Rezoning Transportation Analysis

Petition Number: Insert Zoning Petition #2021-026
General Location Identifier: Tax ID 01914104

Date	Description
02-25-21	First Review (EL)

CITY OF CHARLOTTE, MECKLENBURG COUNTY, NORTH CAROLINA  
FOR  
CIVIL CONSTRUCTION DOCUMENTS  
HENDRICK NORTH LAKE  
REZONING SITE PLAN

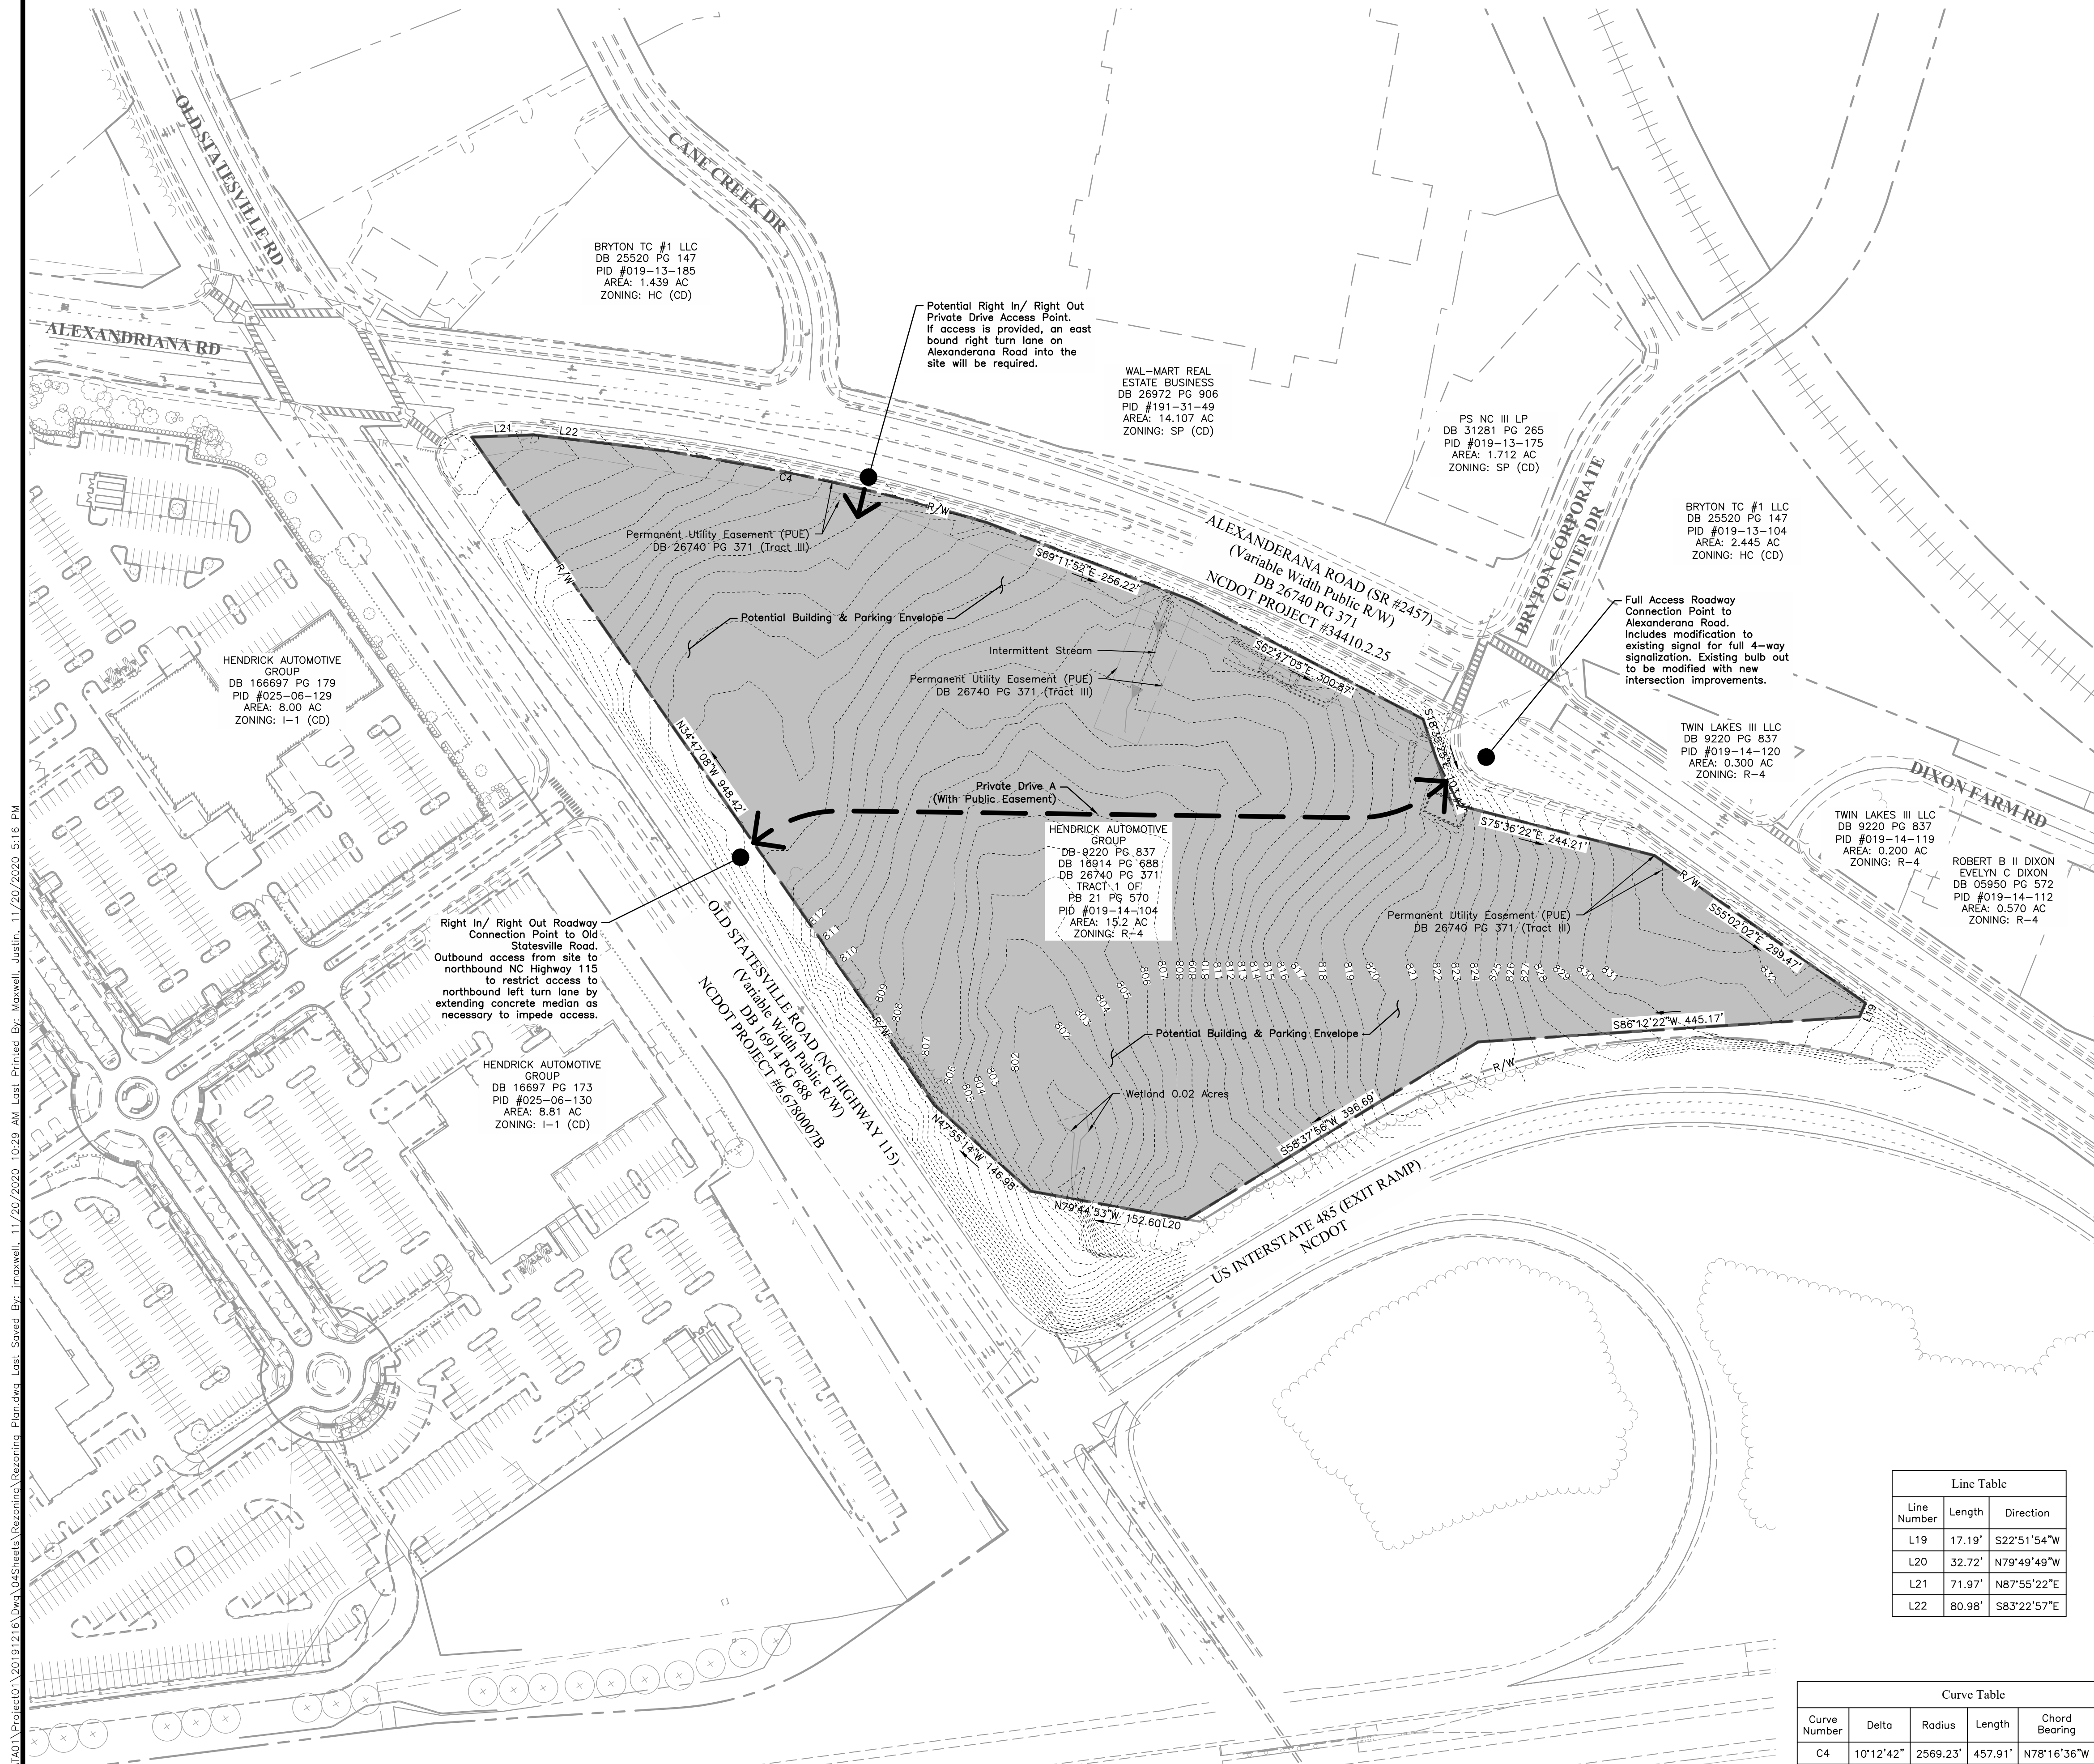
- a. **Eastfield Road:** The future location of curb and gutter is in its existing location.
- b. **Old Statesville Road:** The future location of curb and gutter needs to be installed at the existing edge of pavement, per Chapter 19-174 of the City Code.

- 3. Site plan and conditional note (Section 3.a.) revisions are needed to commit to construct an 8-foot planting strip and 12-foot shared-use path, per Chapter 19-174 of the City Code and the Charlotte BIKES Policy, along Old Statesville Road and Eastfield Road. The site plan shall label and dimension both items from the back of curb and gutter and road centerline.
- 4. Revise the site plan to correct the road name "Alexanderana Road" to "Eastfield Road." Alexandriana Road transitions to Eastfield Road, east of the intersection with Old Statesville Road.

5. A site plan note specifying dedication and fee simple conveyance of all rights-of-way to the City before the site's first building certificate of occupancy is issued is needed. CDOT requests rights-of-way set at 2' behind back of sidewalk where feasible. The site plan shall label and dimension the proposed right-of-way to be dedicated from the road centerline.
6. A site plan note specifying that all transportation improvements will be approved and constructed before the site's first building certificate of occupancy is issued is needed. The petitioner may phase transportation improvements if said improvements and phasing are explicitly described in site plan notes.
